KITTITAS COUNTY COMMUNITY DEVELOPMENT SERVICES

RE: Albulet Shoreline Exemption Permit (SX-20-00004) – Transmittal of Comments Received and Request for Additional Information

SITE PLAN
2014-034

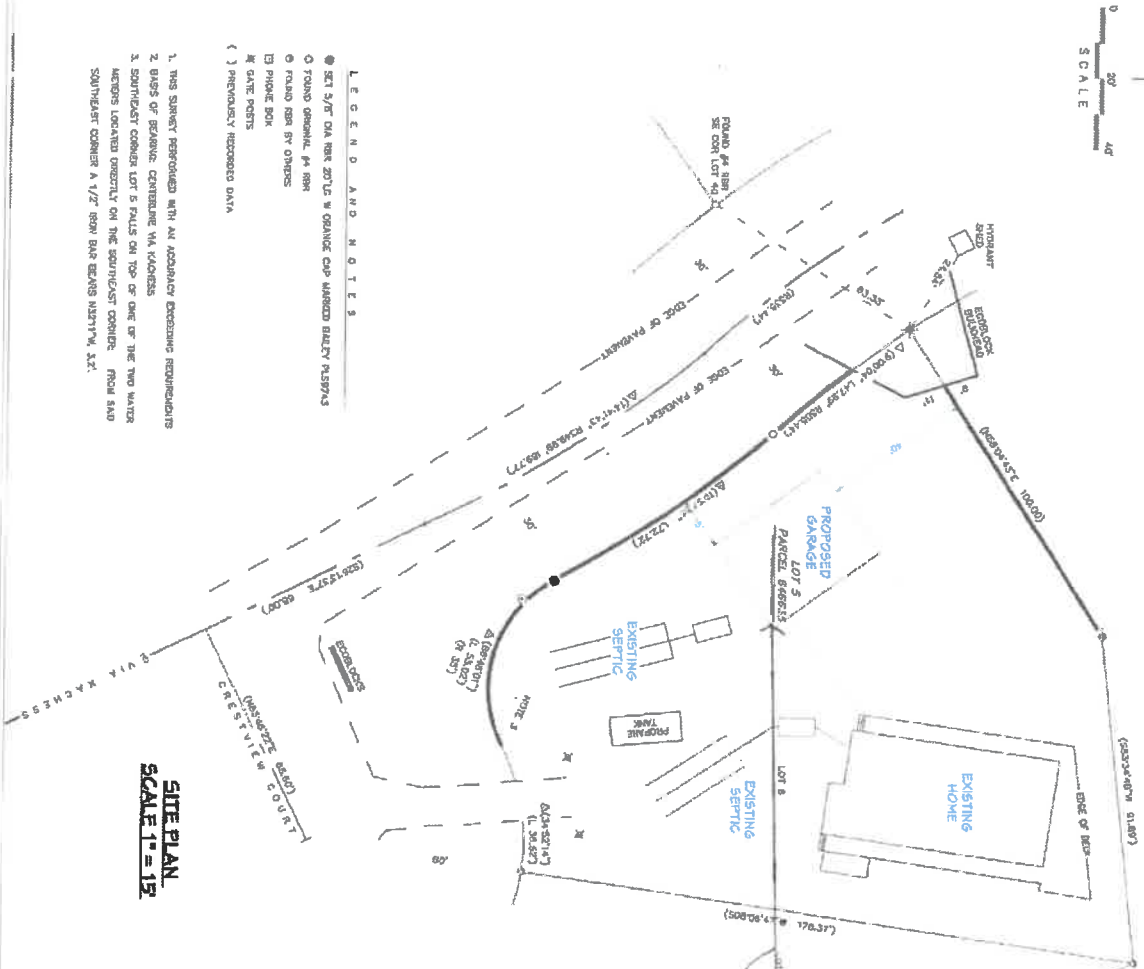
CDS staff has reviewed all submitted information and upon detailed review of your site plan, it was discovered that the required 25' front yard setback is not met. Your site plan indicates there is only 15' from property line to closest edge of proposed garage structure. There are two options to correct this issue moving forward:

1. The preferred path forward is for you to reposition your proposed garage structure so that it meets all setback requirements (both zoning setback requirements and the shoreline buffer/structural setback requirements). Please submit an updated site plan that reflects the zoning setback requirements pursuant to KCC 17.56.060 (Front Yard: 25', Side Yard: 10', and Rear Yard: 10' to main building) and the Shoreline buffer and setback requirements (115') pursuant to KCC 17B.05.020C and KCC 17B.05.050.
